Council Reference: DA09/0830.16
Your Reference: MP07/0179.06

10 December 2020

MP07_0179 Mod 6 - Response to invitation for comments

Figure 1: Approved Level 1 Plan

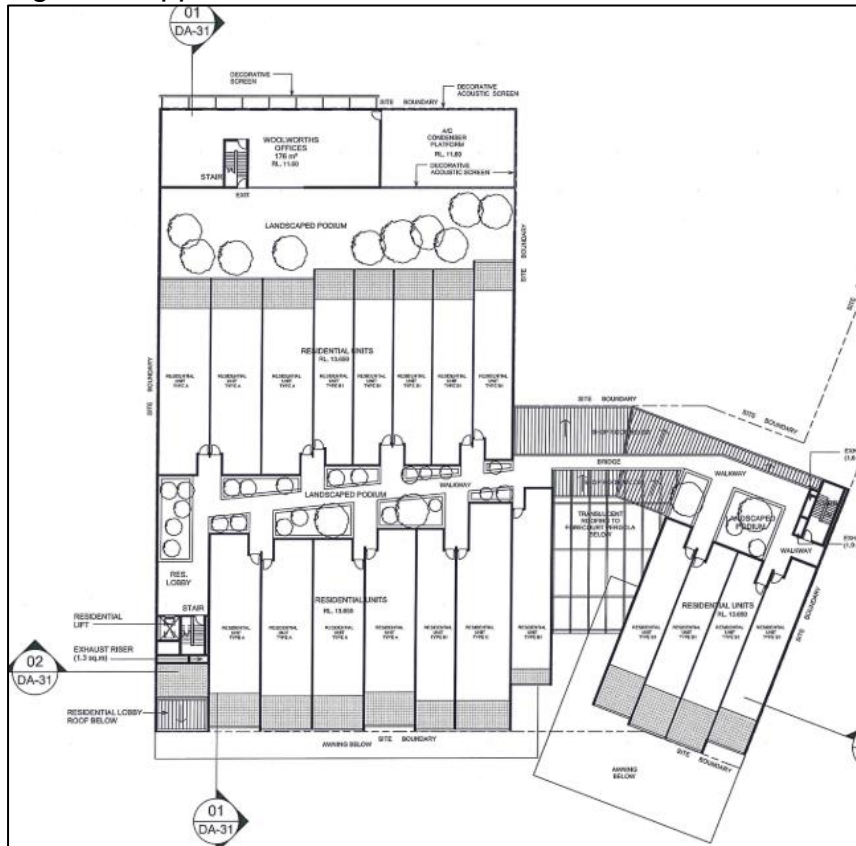
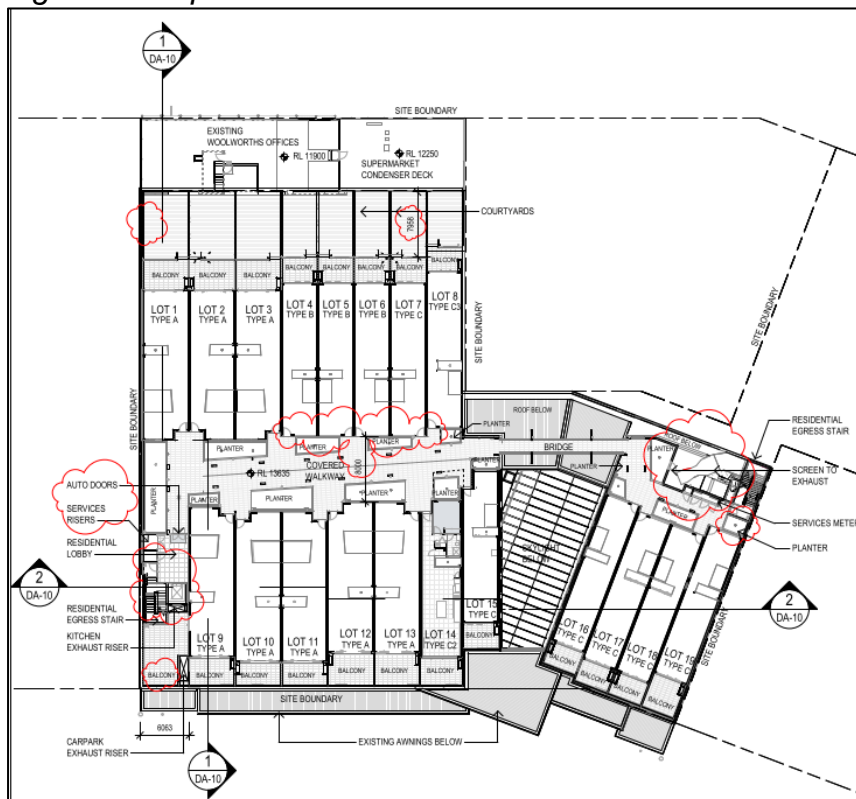
As set out hereunder Council have no objection in principle to the relocation of Units 1 - 8 and 20 - 27 westward by 2m towards Hastings Road to increase solar access and natural ventilation in the central landscaped podium and walkway between Buildings 1 and 2. It is acknowledged that limited detail has been provided in relation to the visual impact of the revised proposal when viewed from street level on Hastings Road, and that no revised shadow diagrams or view sharing analysis has been provided. However it is considered that the proposed modification would have a negligible impact in terms of visual impact, overshadowing or view sharing.

Council, however, does not support the proposal to allocate the rooftop landscaped area on Level 1 adjacent to the Hastings Road frontage to private open space for units 1 – 8.

It is acknowledged that this area is not currently accessible directly from any of the residential units, and has been landscaped in the approved plans to function as a view field from the units as opposed to a recreational area. However there is a deficiency of communal open space associated with the development and it is considered that the proposed modification to allocate this area to private open space represents a missed opportunity.

It is considered that it may be more appropriate to allow individual accesses from Units 1 - 8 as proposed, but to retain this as a single area landscaped area which also allows for access for other unit occupiers through the rooftop access. The

In relation to the proposed modification to allocate the landscaped rooftop area adjoining Units 1-8 to these units, concerns are raised.

However the current proposal to allocate the area as private open space for Units 1 - 8 would result in the loss of any opportunity to achieve this. As demonstrated from the proposed plans, it is possible to allow for access directly from Units 1-8 to this area, and as such an opportunity to create a communal open space at this location, directly accessible from a number of units, with the potential to allow access for other unit occupiers through the rooftop stairs.

On this basis, it is recommended that the applicant be requested to reconsider this modification and to retain this area as communal open space accessible to as many units as possible.

Figure 3: Approved Level 2 Plan

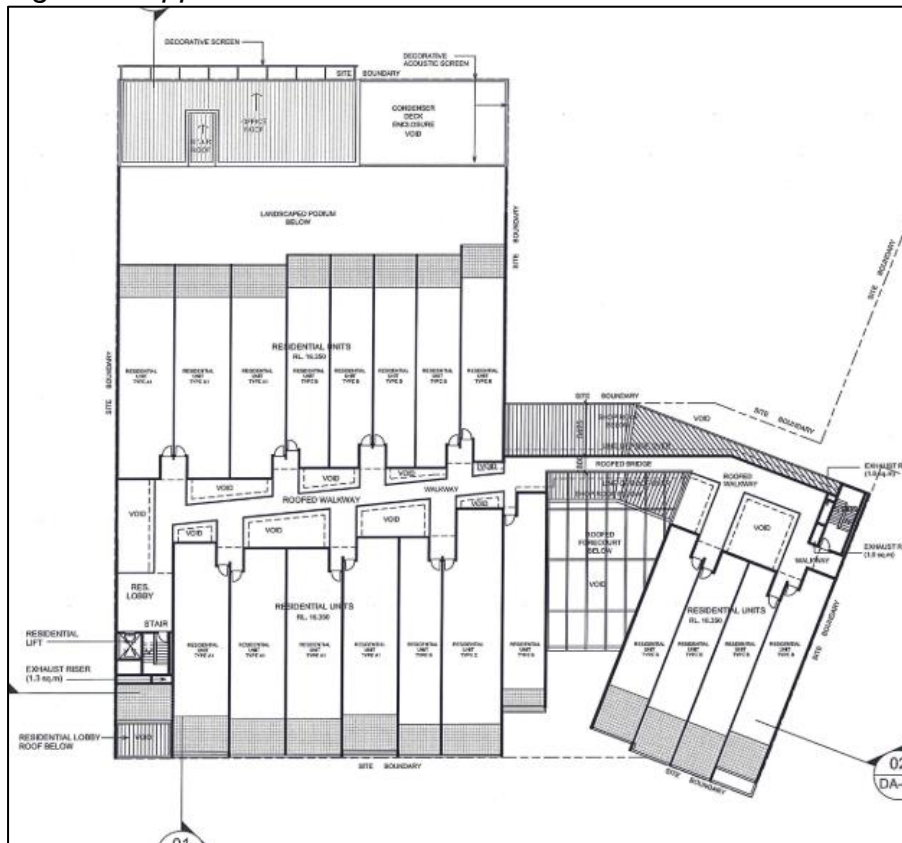
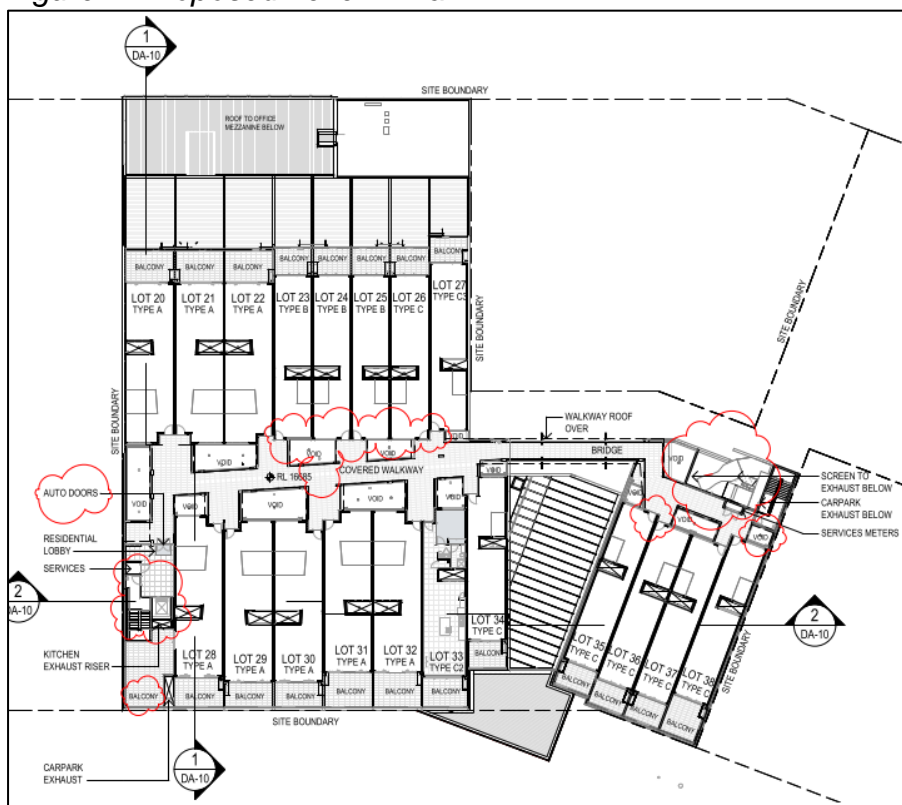
No objection is raised to the modification of the landscaped podium or the relocation of units 1-8 to facilitate its increased width, nor the other minor modifications to the plans.

- Minor changes to the entries to Unit's No's 35 and 36;
- Minor changes to screen exhaust behind Unit's No's 35-38;
- Minor changes to entries of Unit No's 23-27;
- Insertion of automatic doors;

Figure 7: Approved Section Plan

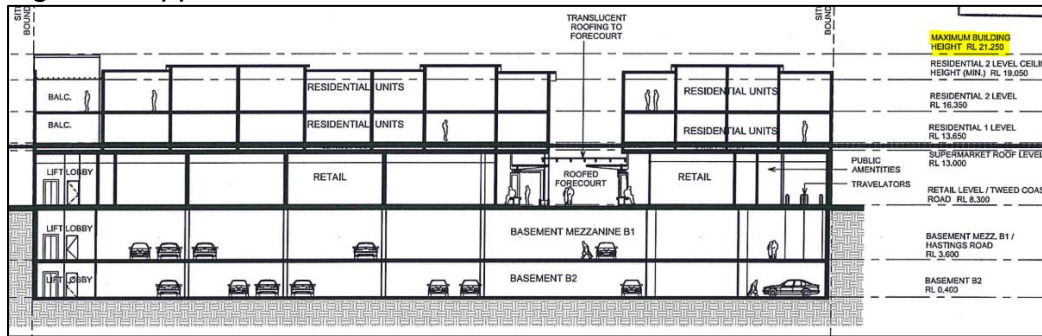
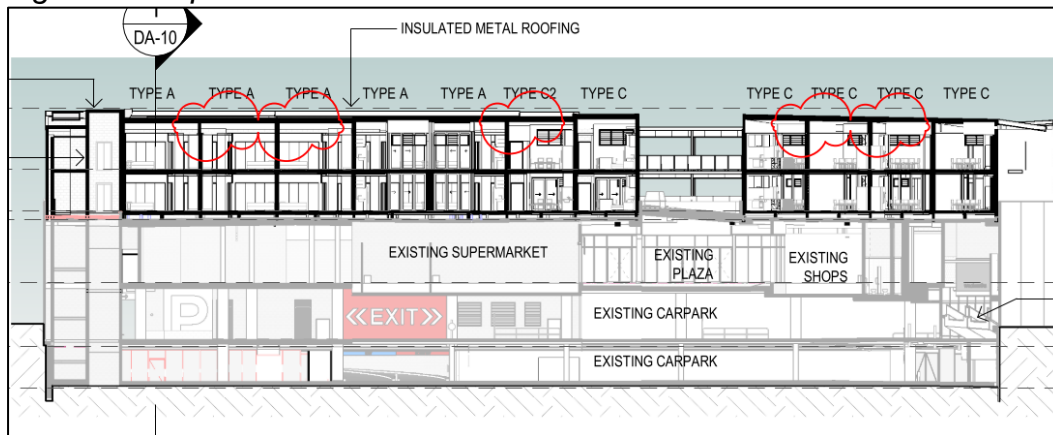
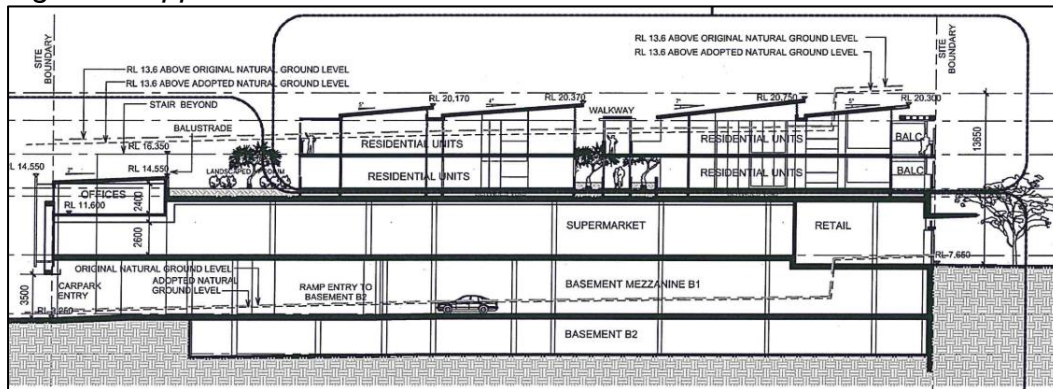
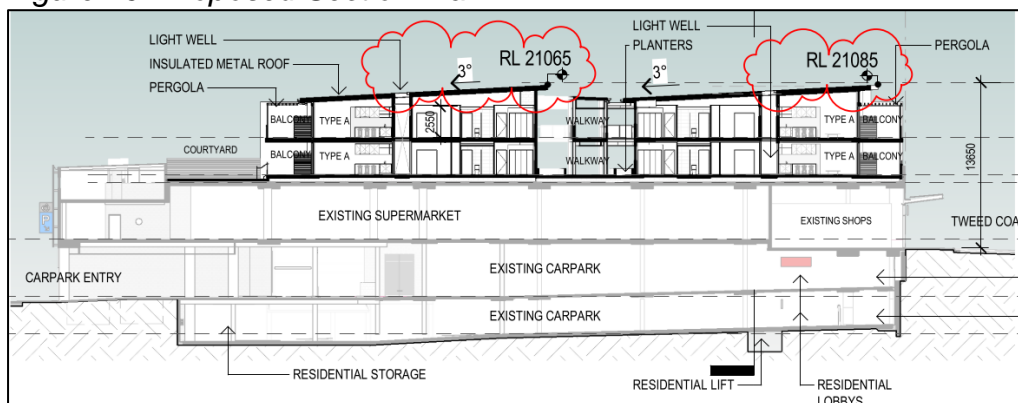
While the height of the elevation to Tweed Coast Road is increasing, the maximum building height of the building is maintained. However Council has concerns in relation to the proposed changes to the roof profile. The modulated roof design as approved is more consistent with the roof lines controls for Bogangar/Cabarita in the Development Control Plan 2008 – Section B19. The current proposal is more monotonous and will contribute little to the streetscape, particularly when viewed from Hastings Road.

In relation to the proposed changes to the roof profile, this appears to be driven by the introduction of lightwells to increase solar access to the units.

The stepped roof profile of the approved development is visually more attractive than what is proposed and more successfully breaks up the bulk of the development. The approved roof plan is also consistent with the roof line controls in the Development Control Plan 2008 (Section B19 – Bogangar/Cabarita beach Locality Plan):

While it is recognised that the driver for the change in the roof profile appears to result from the introduction of the skylights (to provide additional light to internal areas), the upper level will be highly visible from Hastings Road.

As such, the applicant should be requested to address the controls for rooflines in the DCP – Section B19.

The change in the roof profile, will also result in an increase in the overall height of the building. The maximum height identified for the site in the Tweed Local Environmental Plan 2014 (which was adopted after the approval of this application) is 13.6m. While the maximum height in the approved plans (21.250m RL) is respected, the extent of the building at this maximum height is increased. As can be seen from the approved and proposed sections and elevations in Attachment 1.

ATTACHMENT 2 – Shadow diagrams for approved development

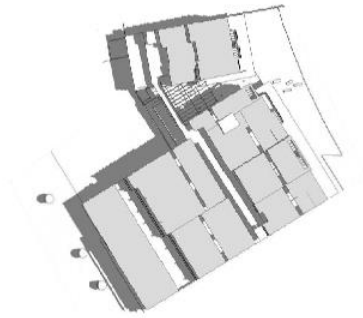
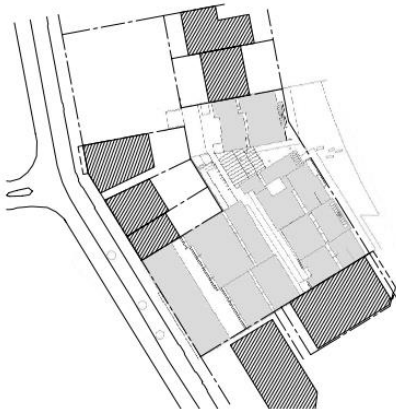
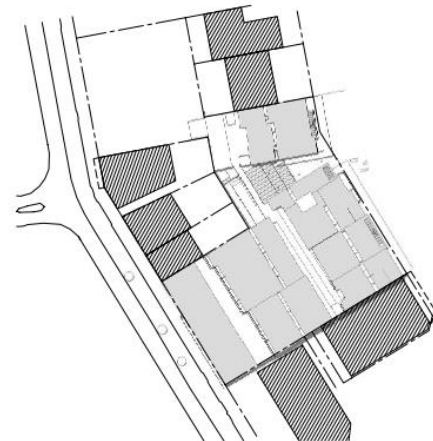
- The applicant has not submitted any updated shadow diagrams for this proposal. Notwithstanding this, a review of the shadow diagrams submitted with the original application (Refer to Attachment 2) would indicate that there would not be a significant increase in overshadowing of adjacent properties as a result of this design change.
